A46 Newark Bypass

Statement of Common Ground with Think Again A46 Winthorpe Action Group

**Statement Of Common Ground with
Think Again A46 Winthorpe Action Group - TA**

Version	Date	Status of Version
Rev 0	October 2024	Deadline 1
Rev 1	November 2024	Deadline 2

DRAWING NUMBER HE551478	ORIGINATOR SKAG	VOLUME HGN	PROJECT REF NO. HE551478
CONWI_CONW	DR	LE	00003
LOCATION	TYPE	ROLE	NUMBER
			C01

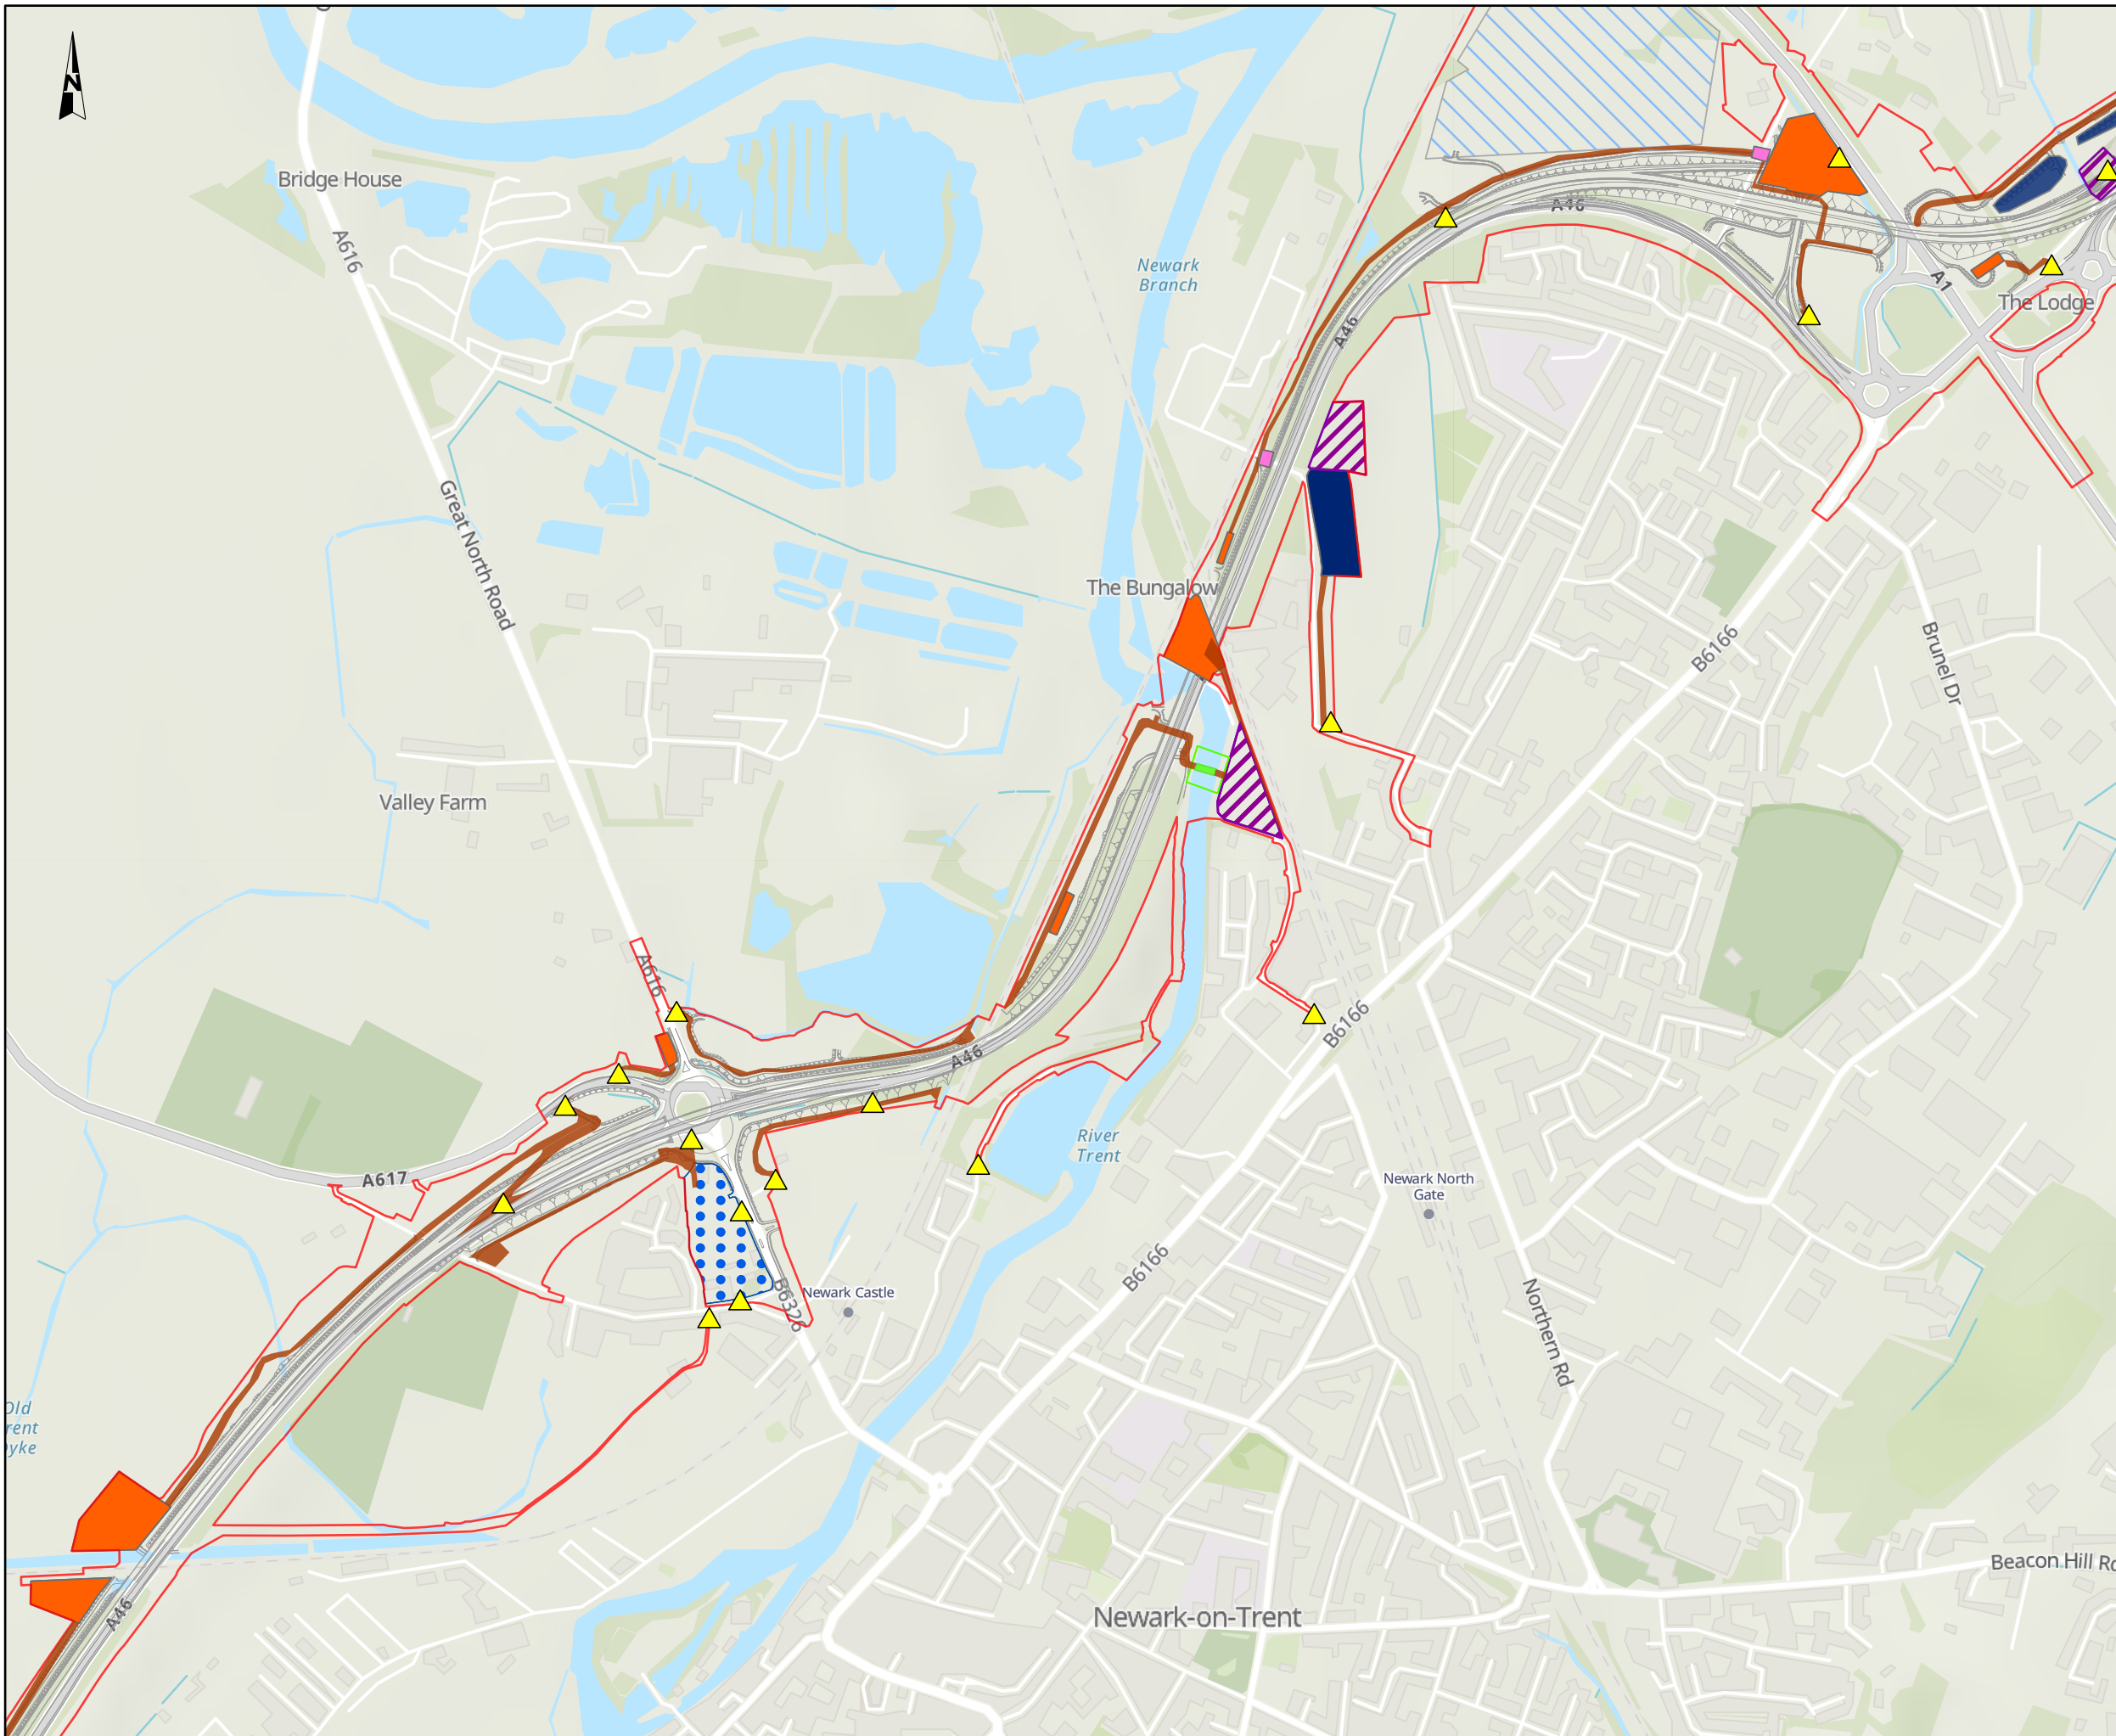
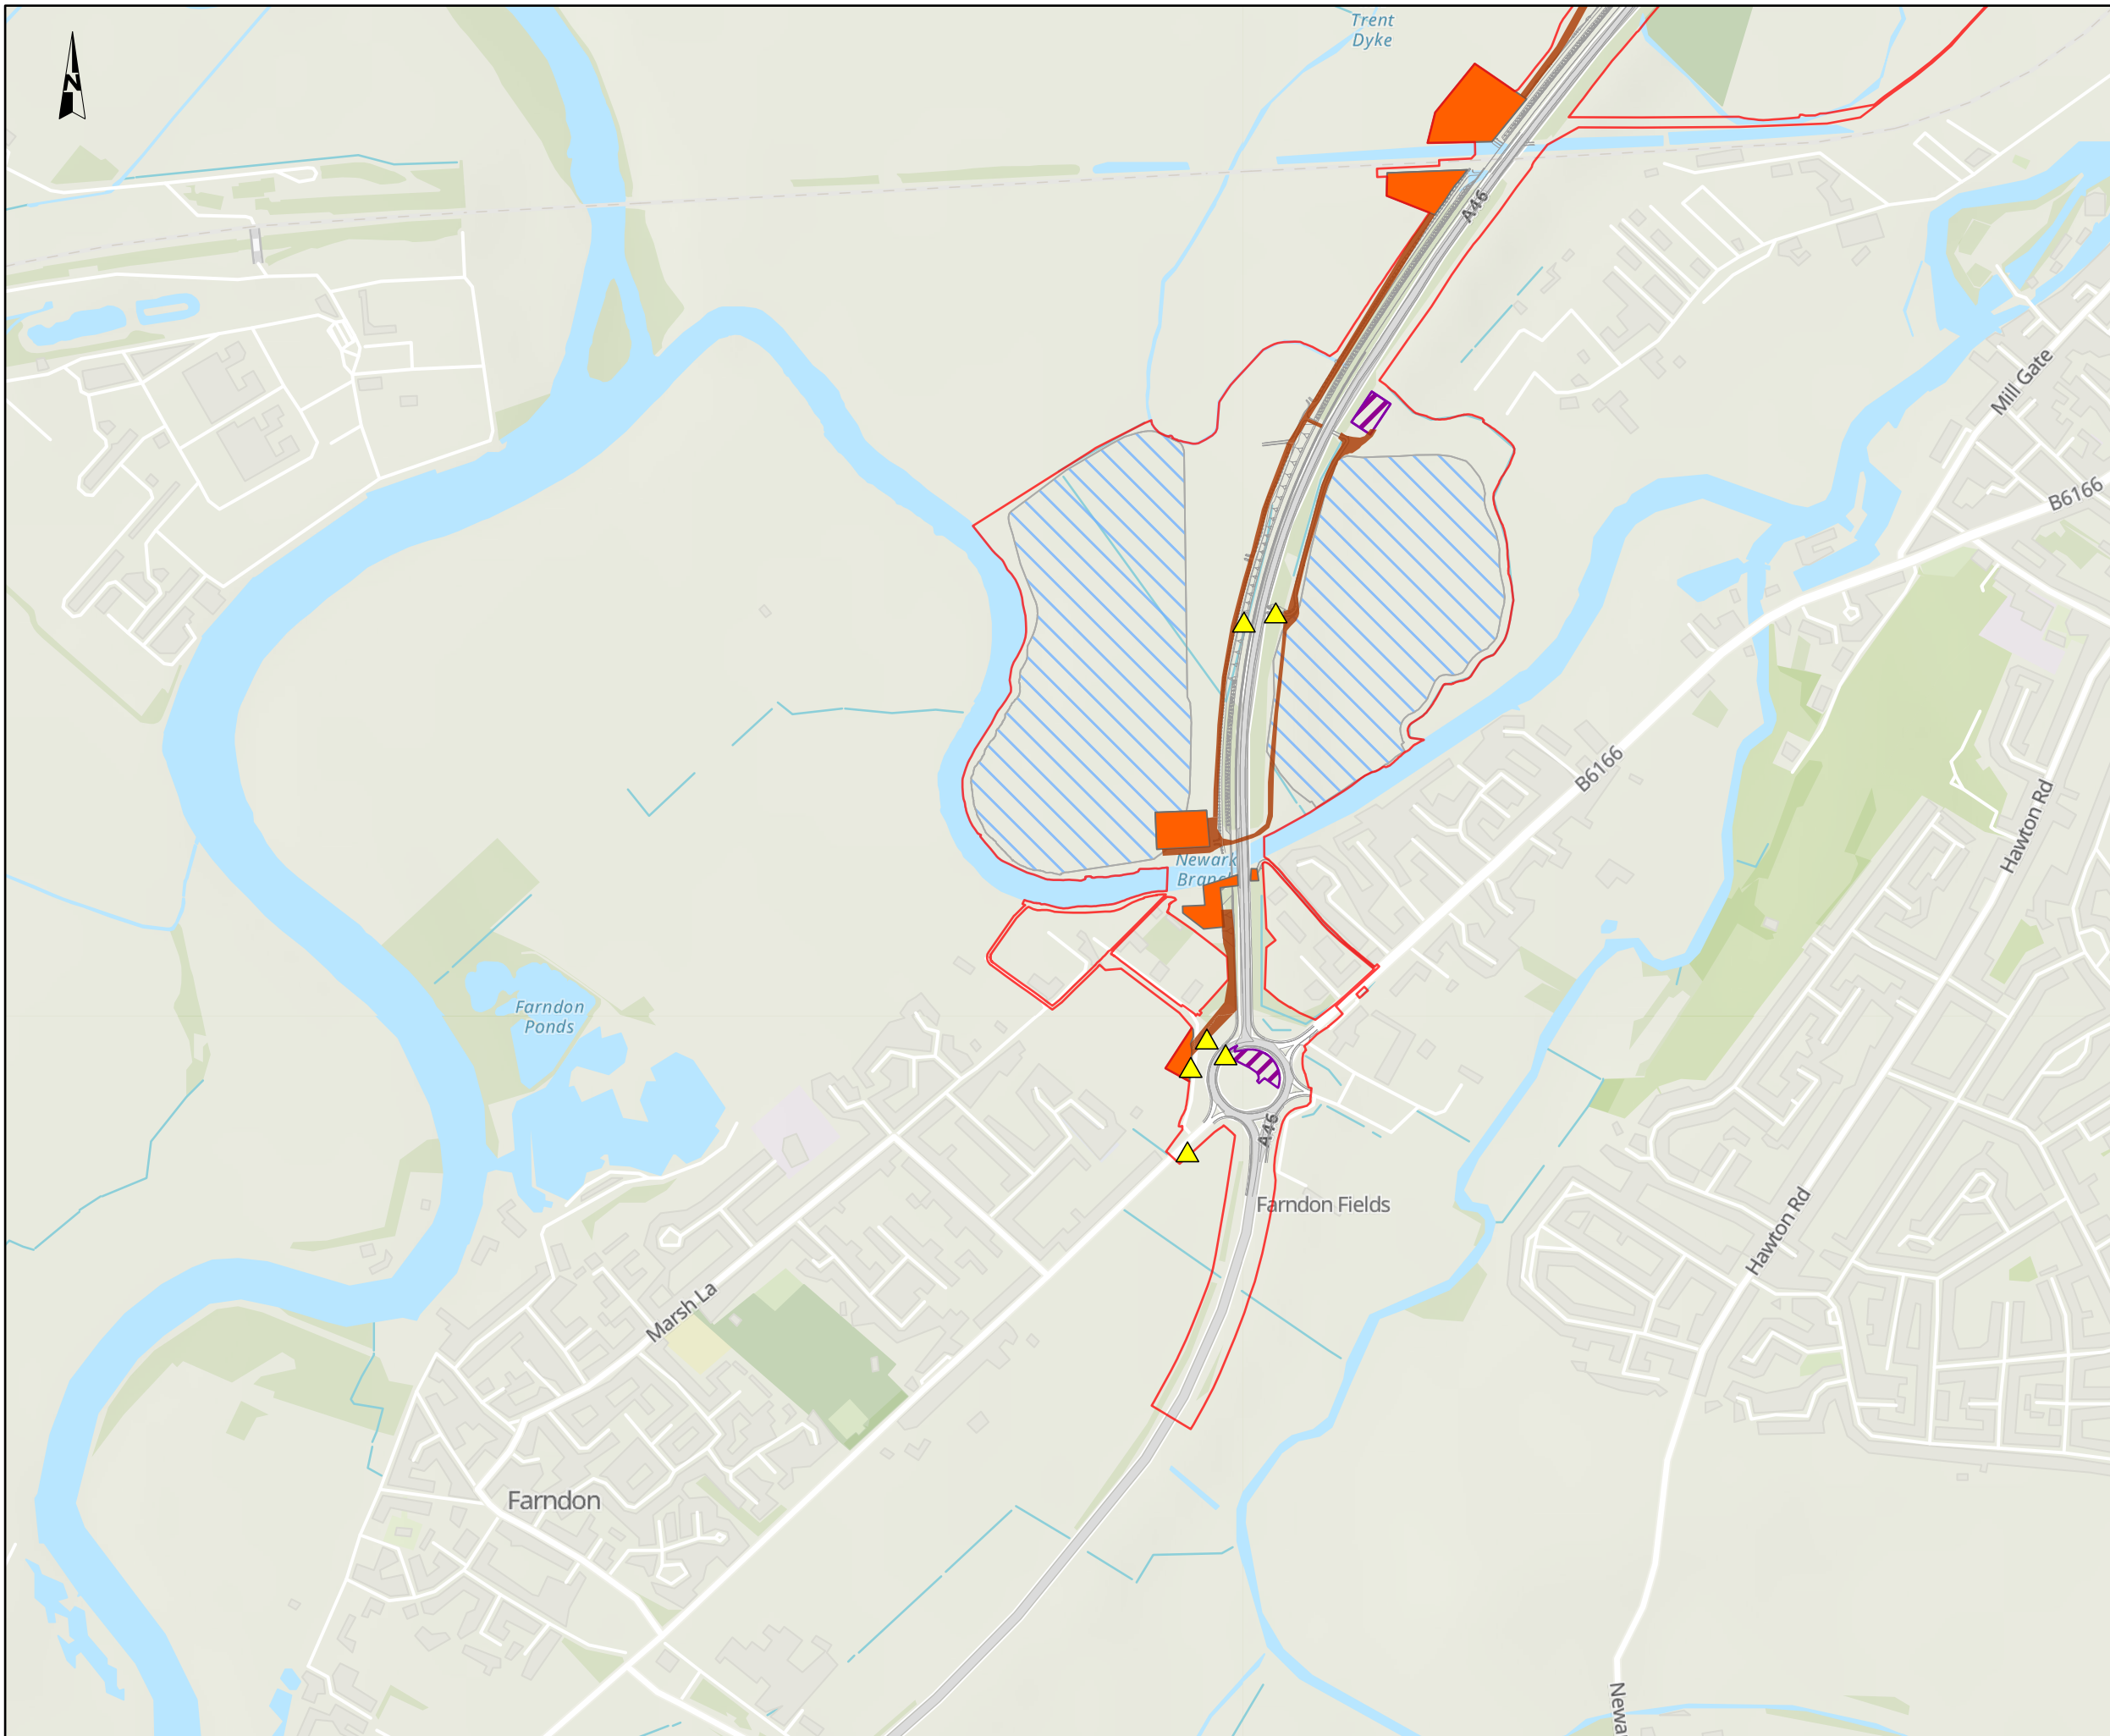
20.	Construction Compounds	<p>Figure 2.4 Locations of Temporary Works Areas Required During Construction of the Environmental Statement Figures [AS-027]</p> <p>Table 2-6 in Chapter 2 The Scheme of the Environmental Statement [APP-046]</p>	What construction compounds and works access facilities will be located in the Winthorpe area?	The location of the construction compounds and works access areas within the Winthorpe area are detailed on Figure 2.4 Locations of Temporary Works Areas Required During Construction of the Environmental Statement Figures [AS-027] and in Table 2-6 in Chapter 2 The Scheme of the Environmental Statement [APP-046].	Agreed	24/09/2024
